Rollin Ridge Commercial, PUD-18-003

Please accept the following revised comments from El Paso County Public Health regarding the proposed commercial development:

**WELL & SEPTIC LOCATION PLAN
PUD DEVELOPMENT PLANS
ROLLIN RIDGE ESTATES COMMERCIAL CENTER**

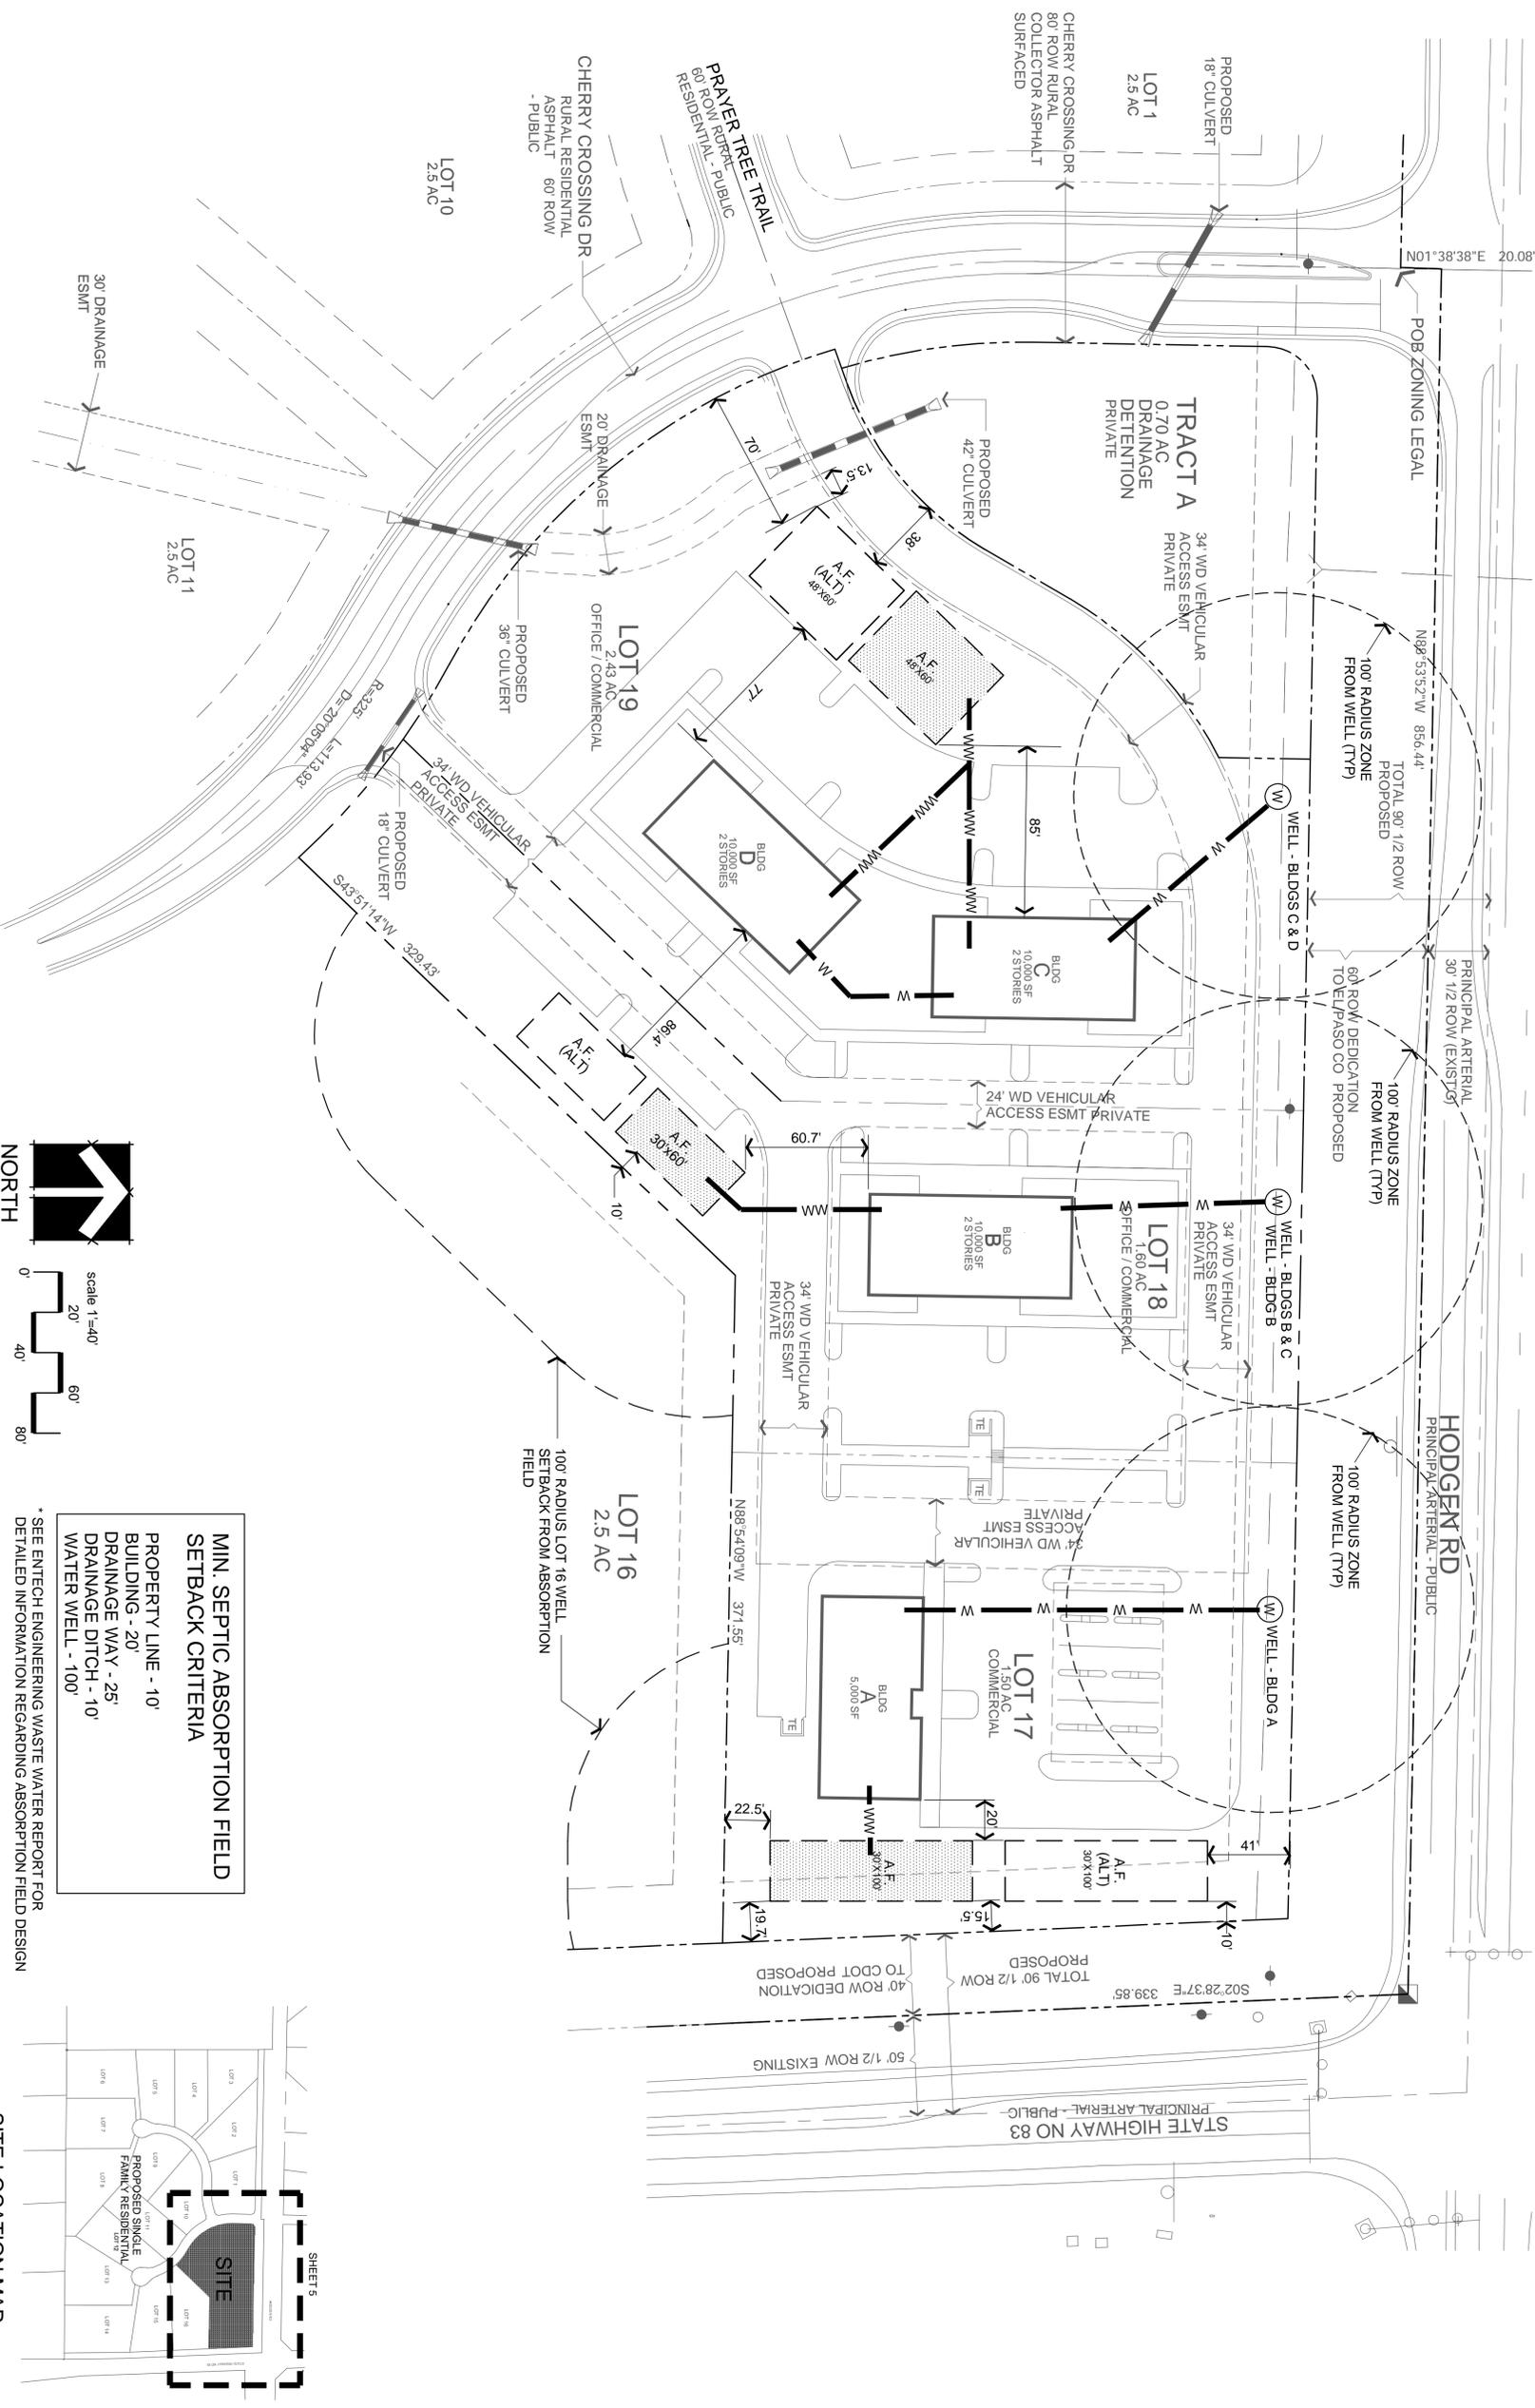
- **The Letter of Intent indicated a gas station with a convenience store is proposed in the NE corner of Tract B. As discussed in the 03Apr2018 meeting, the convenience store shall be limited to pre-packaged food and beverages. Extensive preparation of food creates higher strength wastewater, and requires significantly more water to operate. As discussed, extensive food preparation in Tract B will not be supported. The onsite wastewater treatment system for the convenience store must incorporate pressure distribution into the required design.**

- **The primary and secondary soil treatment areas identified in Tract B must be protected from compaction during all development and construction processes. Severe damage to these areas may cause further limitations to the scope of the commercial development of Tract B.**

- **The 24Nov2017 Entech Engineering, Inc., Soil, Geology, Geologic Hazard, and Wastewater Study reported that the majority of OWTS's on the site will require a professional engineer design due to shallow bedrock and poor soils. All commercial development shall have onsite wastewater treatment systems designed by a Colorado Registered Professional Engineer.**
